From: Anita Gardner
Sent: 13 December 2018 11:05
To: Planning.Responses
Subject: FW: 125 Sea Road, East Preston EP/136/18/PL
Attachments: ITL12278-SK-013 Revised Tracking 1of2.pdf; ITL12278-SK-014. Revised tracking 2of2.pdf

You may be aware of objections expressed by some neighbours to our site at the above address, concerning our planning application for a minor material amendment to rearrange the car parking spaces within our site.

This is logged under Arun Planning Ref: EP/136/18/PL.

ROCCO HOMES
TUDOR COTTAGE, SEA ROAD,
EAST PRESTON
VEHICLE PATHS

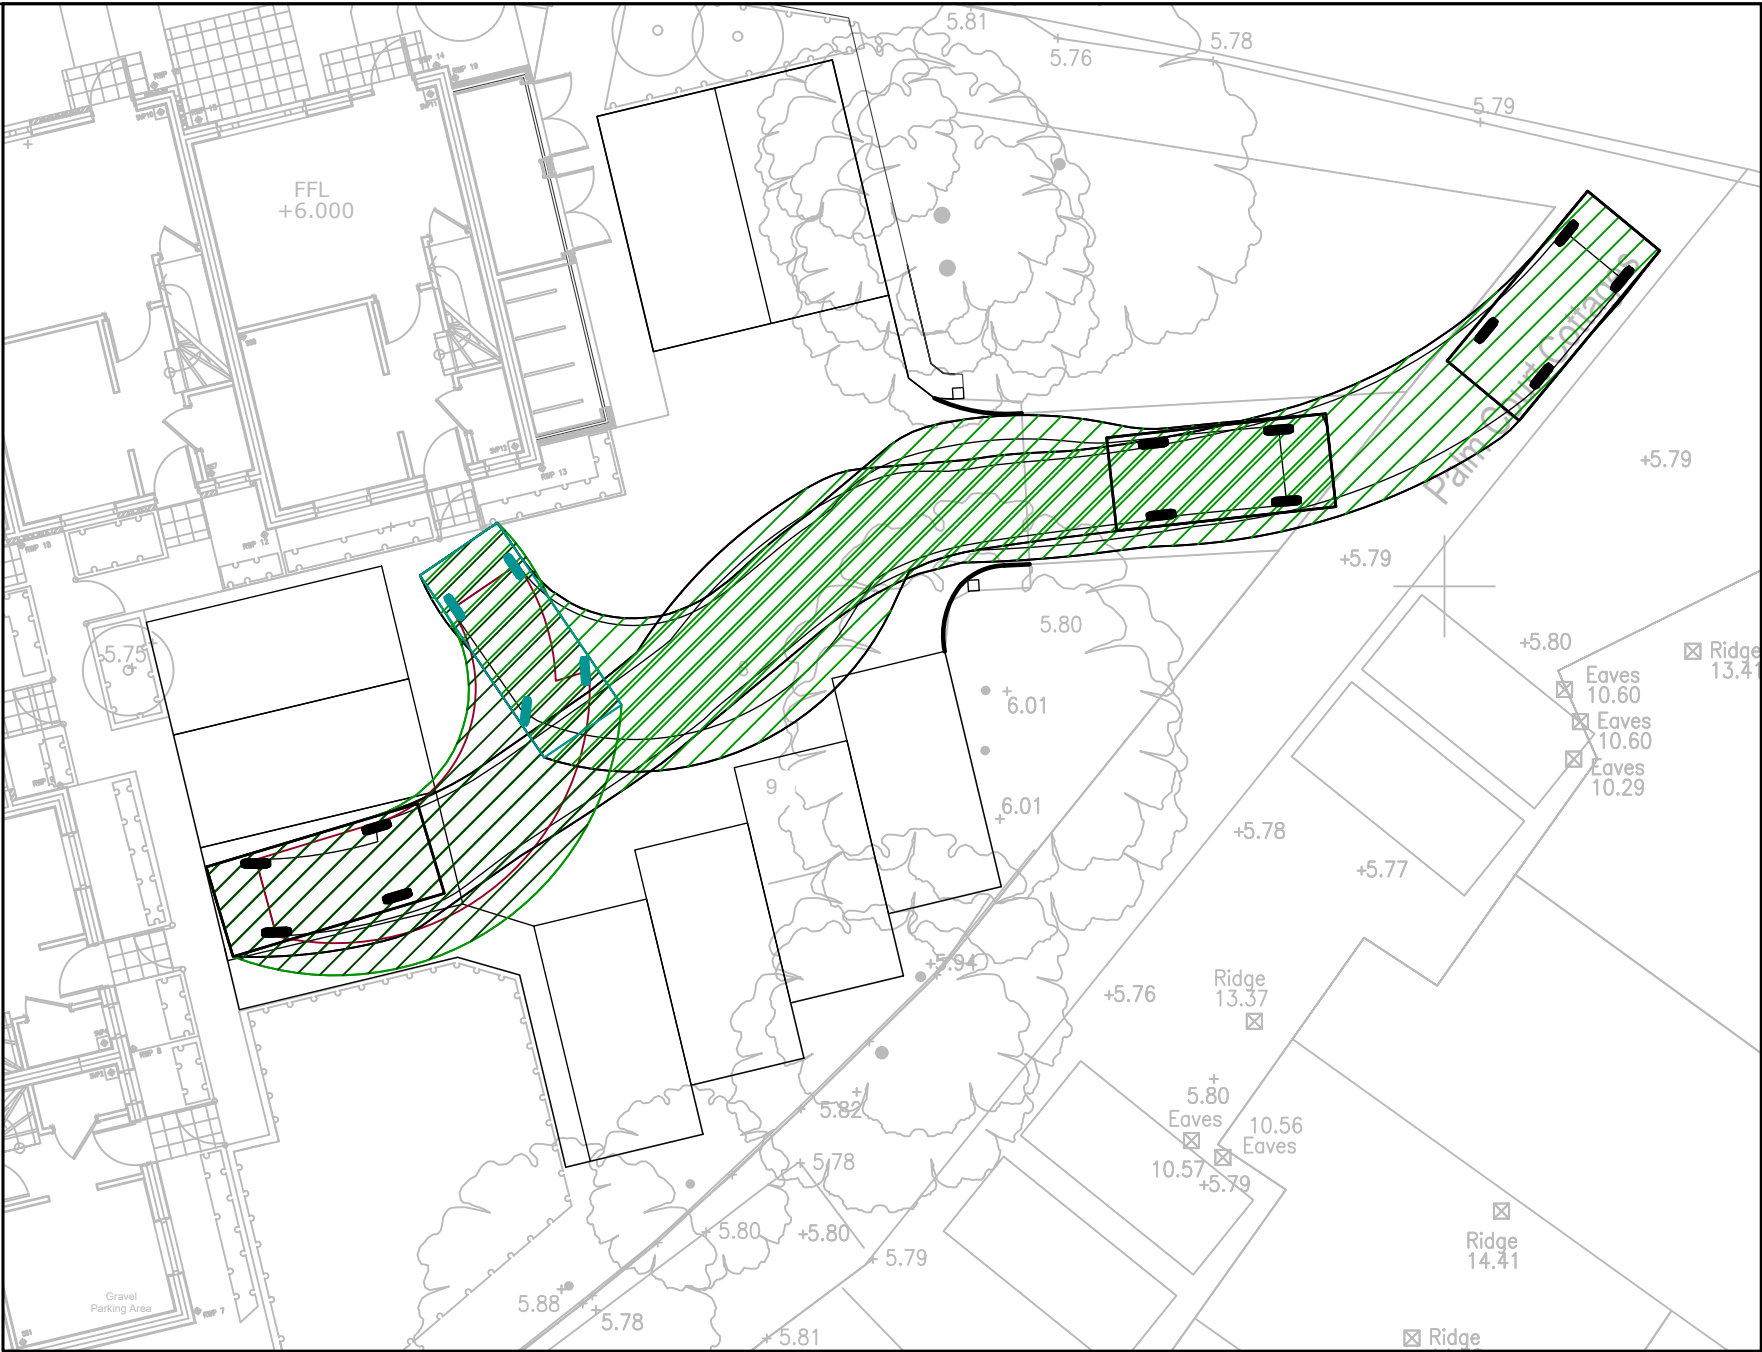
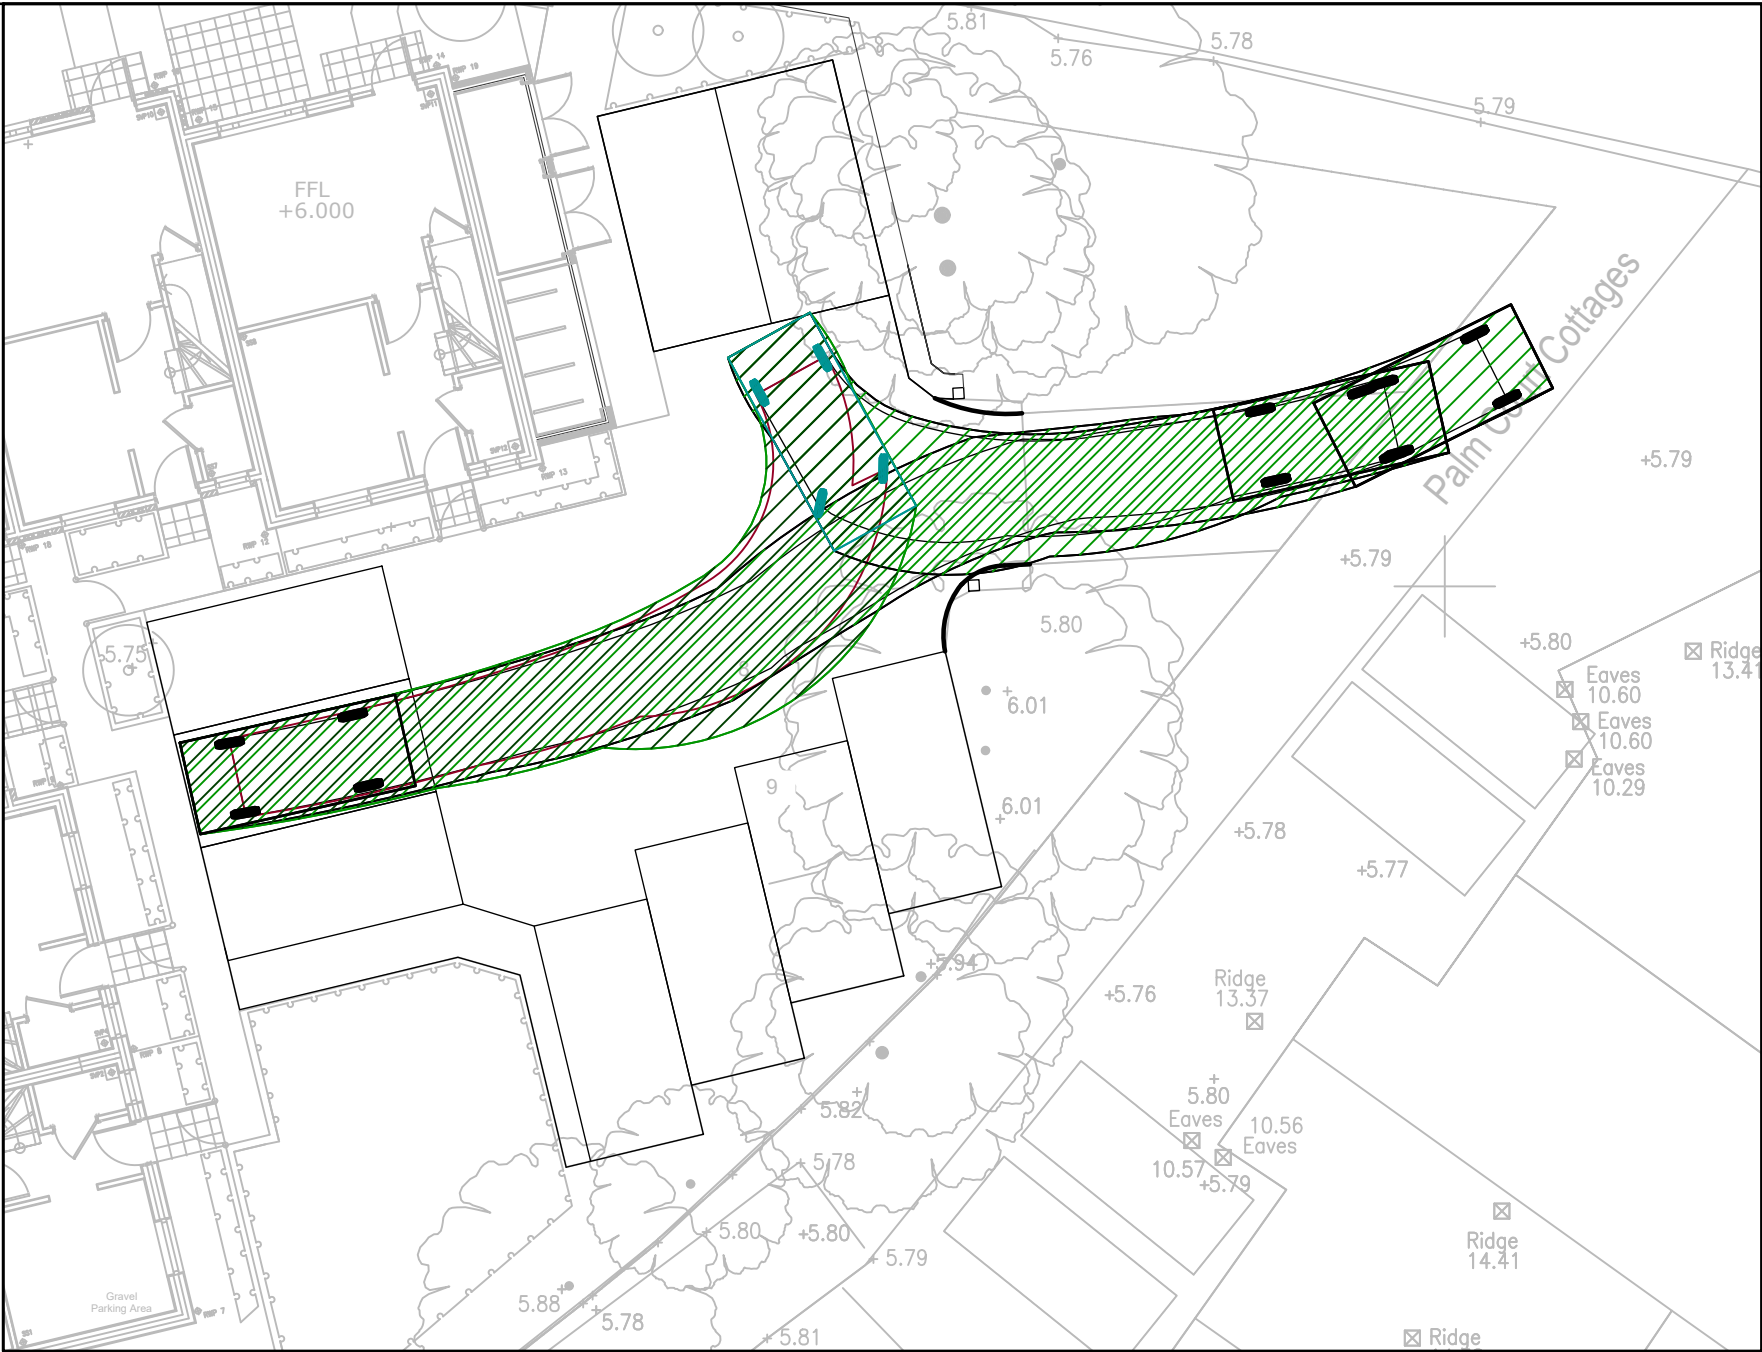
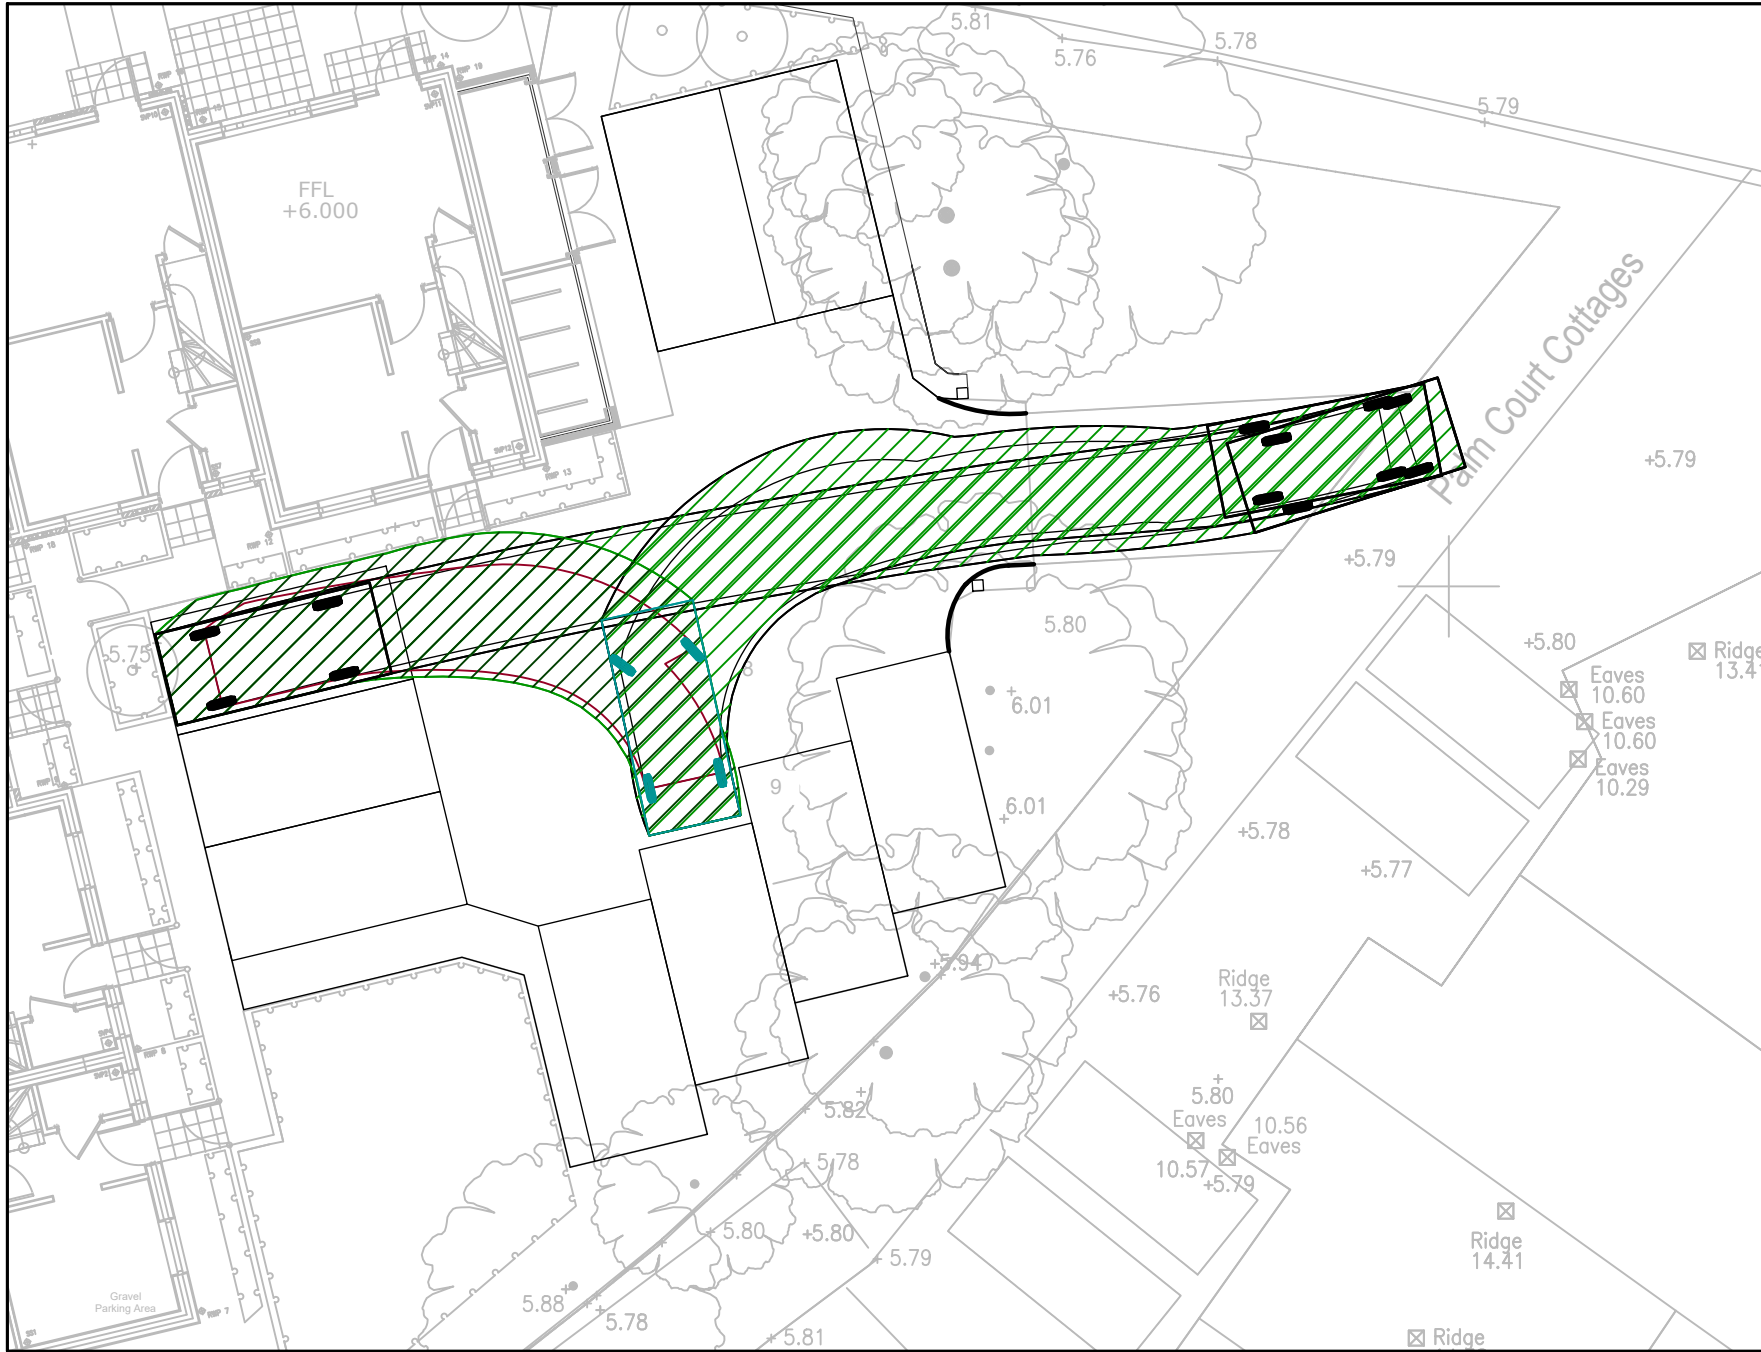
I have spoken with my Team Leader this morning and write to request that the Pringuer James drawing is updated to accord with the other later tracking plan. This will prevent potential confusion at Committee when there are essentially 2 different routes indicated. Will it be possible for this to be provided by lunchtime today? It is my intention to then refer to the later plan in the plans condition.

Ms. Risbridger's concerns centred around the angle of entry and exit from our site shown on the tracking drawings prepared by our engineers, Pringuer James (see attached) which were submitted with the application. She felt that the entry and exit route shown on those

drawings depicted vehicles coming too close to the terrace of Palm Court Cottages before turning north to South Strand.

If it would help, we can ask Pringuer James to amend their drawing to show this route of entry and exit and this proposed drawing could replace the earlier Pringuer James drawing - hopefully without having to re-consult - as this would be a very minor and non material amendment.
